|  | Scale | AS SHOWN | Drawn by | ROLLING HILLS RANCH FILING 3 AT MERIDIAN RANCH GRADING-EROSION CONTROL PLAN GRADING CUT-FILL LAYOUT |  MERIDIAN RANCH | TECH CONTRACTORS 11886 STAPLETON DRIVE FALCON, CO 80831 TELEPHONE: 719.495.7444 FAX: 719.495.2457 | 1 | - | - | - | | |

Construction Drawings_V2_Comments.pdf Markup Summary

Subject: Contractor
Page Label: 30
Author: EPC Stormwater - Glenn Reese
Date: 6/18/2021 12:02:43 PM
Status:
Color: ■
Layer:
Space:

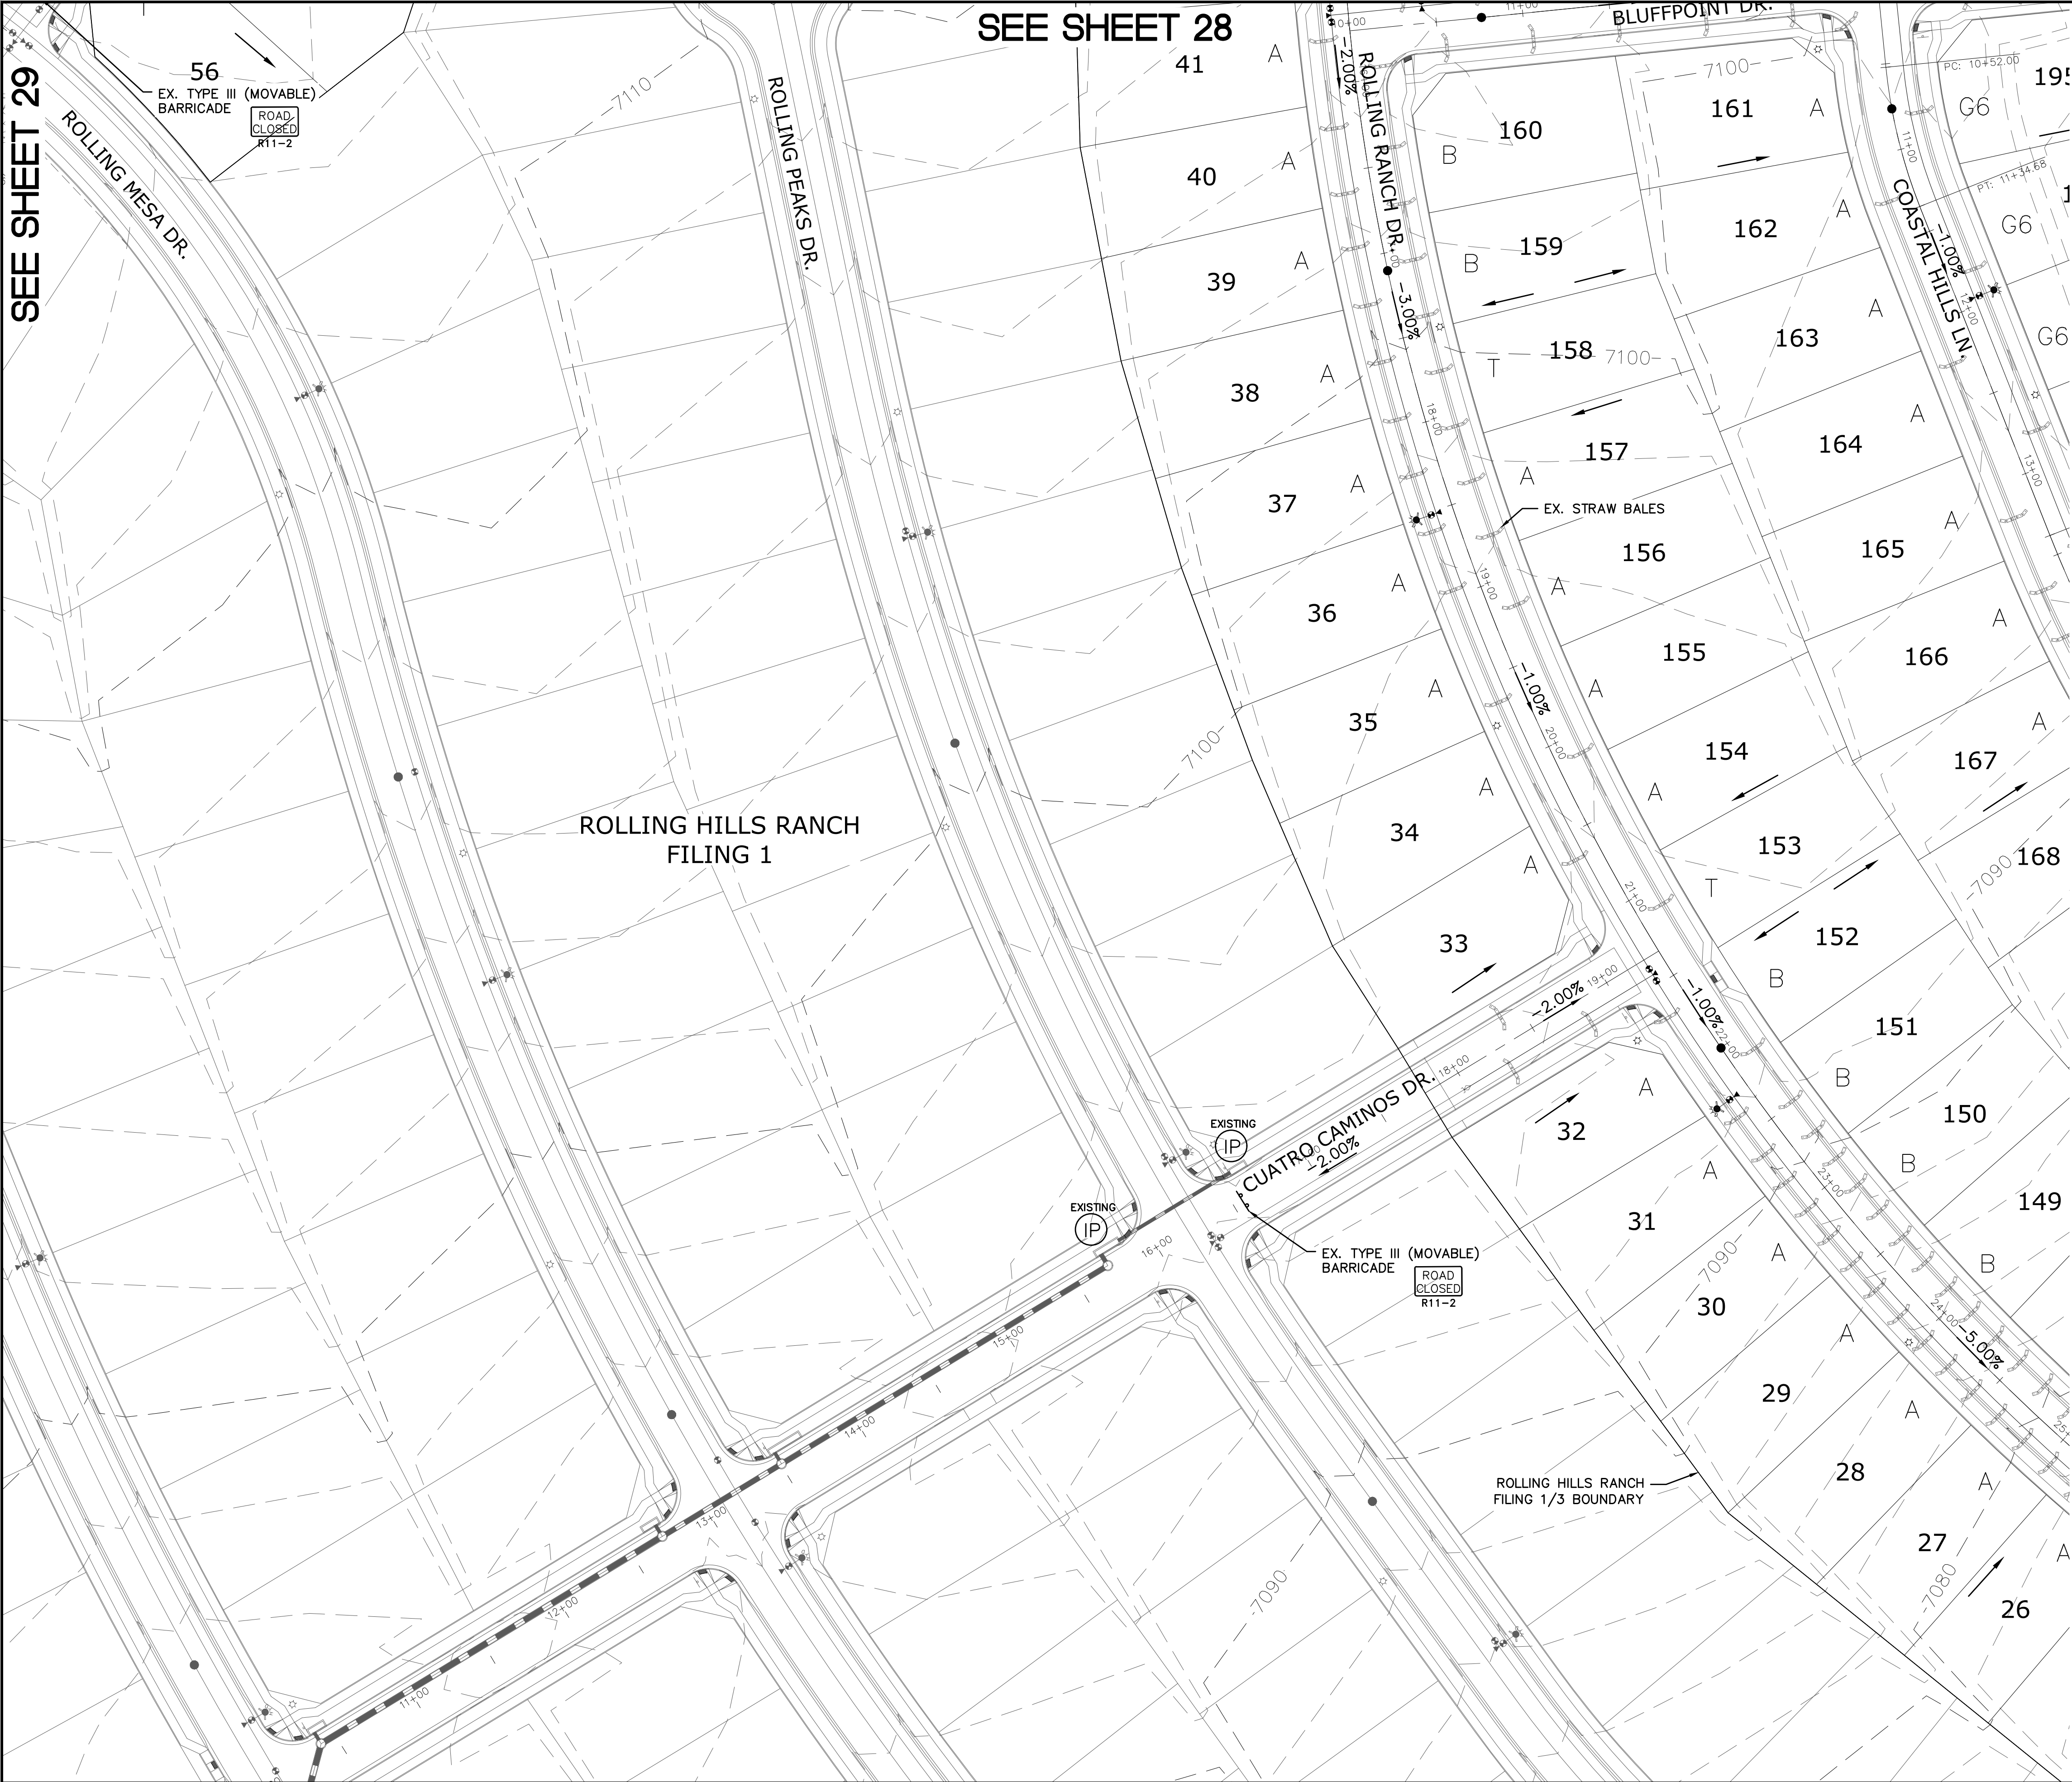
These details are still not see within this plan set (per Review #1 comment). Please include these details.

Erosion control blanket is not proposed with this plan set. No change to the plans.
